DRB Application No.: <u>02-01296</u>	Project # <u>1001987</u>
Project Name: <u>Vista Emantado</u>	EPC Application No.: <u>02 EPC - 00836</u>
Agent: <u>Cristo Basanich</u>	Phone No.: <u>765-1020</u>

SUBJECT: St. John's United Methodist Church, Project # 1001987

DEVELOPMENT REVIEW BOARD--SPEED MEMO

REVIEW COMMENTS

DRB SUBMITTAL SHEET #1 - SITE PLAN

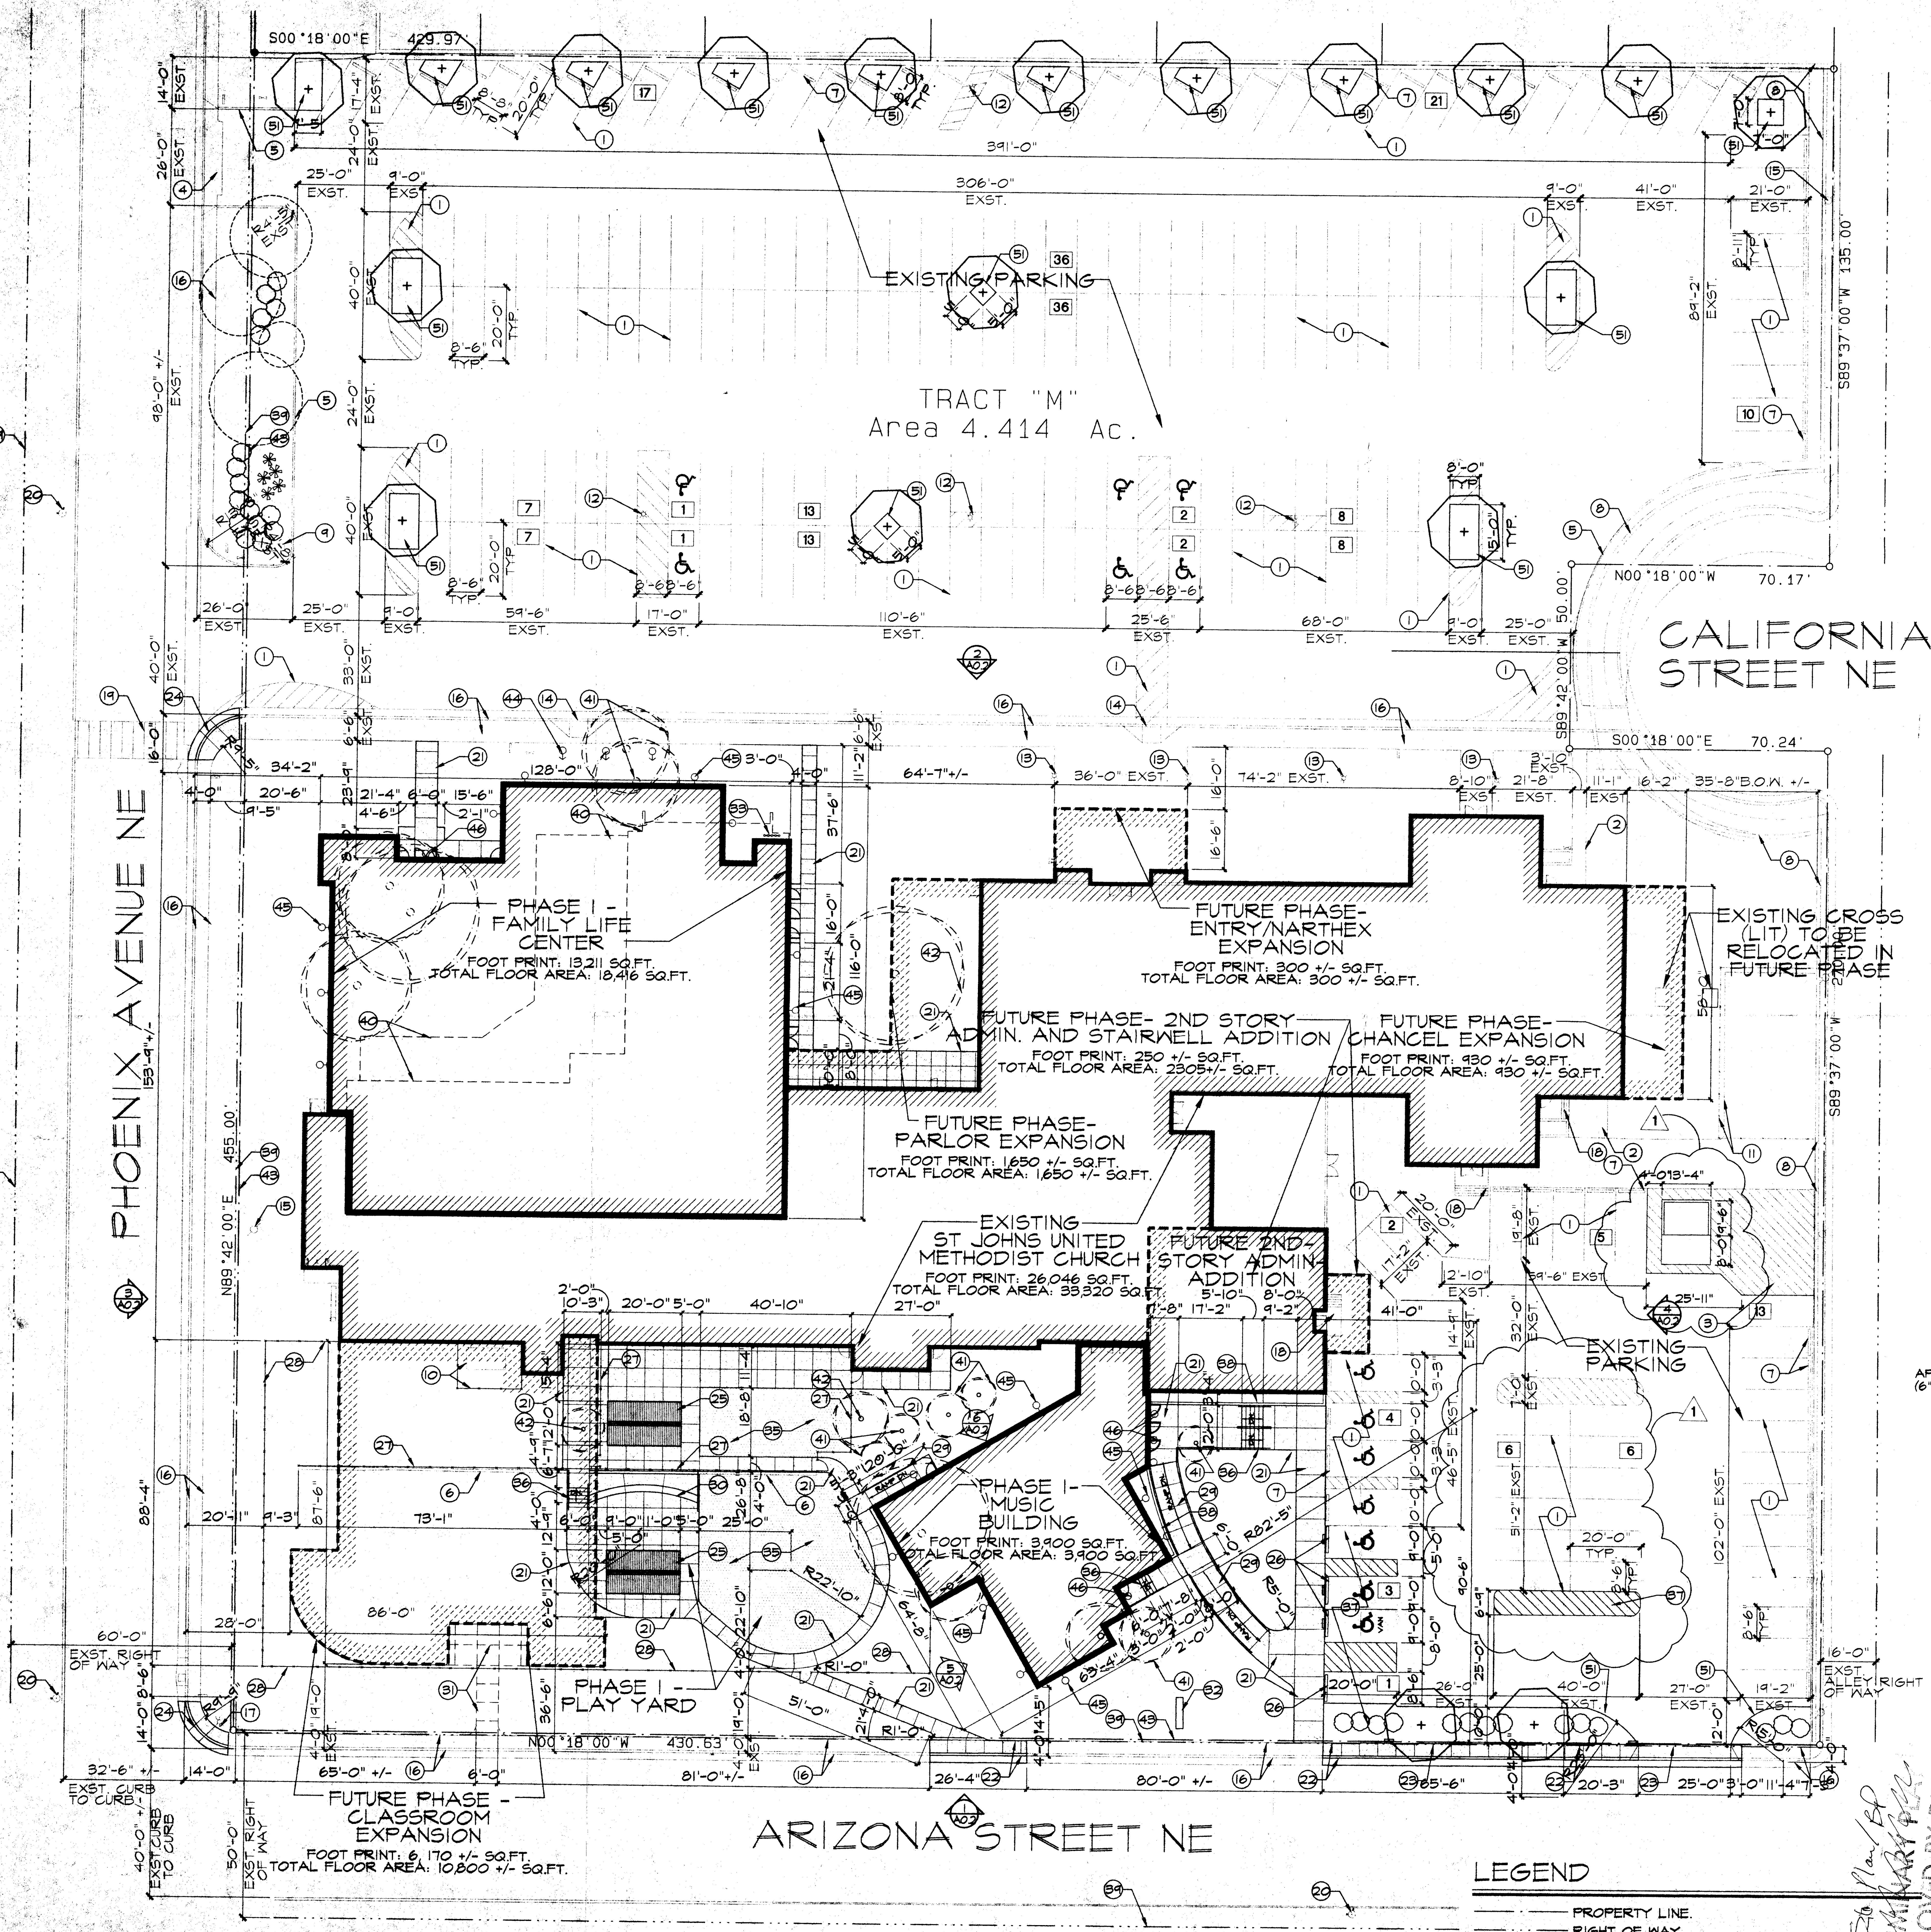
1. Notation #1 under General Notes should include language that clarifies approval delegation to DRB pertains to portions designated as "future phases."
2. The parking spaces along the east property line that exist adjacent to the tree wells are not meeting parking space standards. The parking regulations require the parking spaces to be at least 15' in length to qualify for compact spaces; these parking spaces are 12' in length. The applicant will need to modify the plan to remove these parking spaces and to make modifications to ensure that these areas will not be used for parking of cars. The landscape area could be expanded in this area or the asphalt can be delineated to discourage parking of cars.
3. The signature block for DRB approvals is missing from the submittal and needs to be inserted on the front sheet of the submittal.

③ Use Fire Marshall's stamp of approval
showing location of Fire Hydrants on Site Plan.
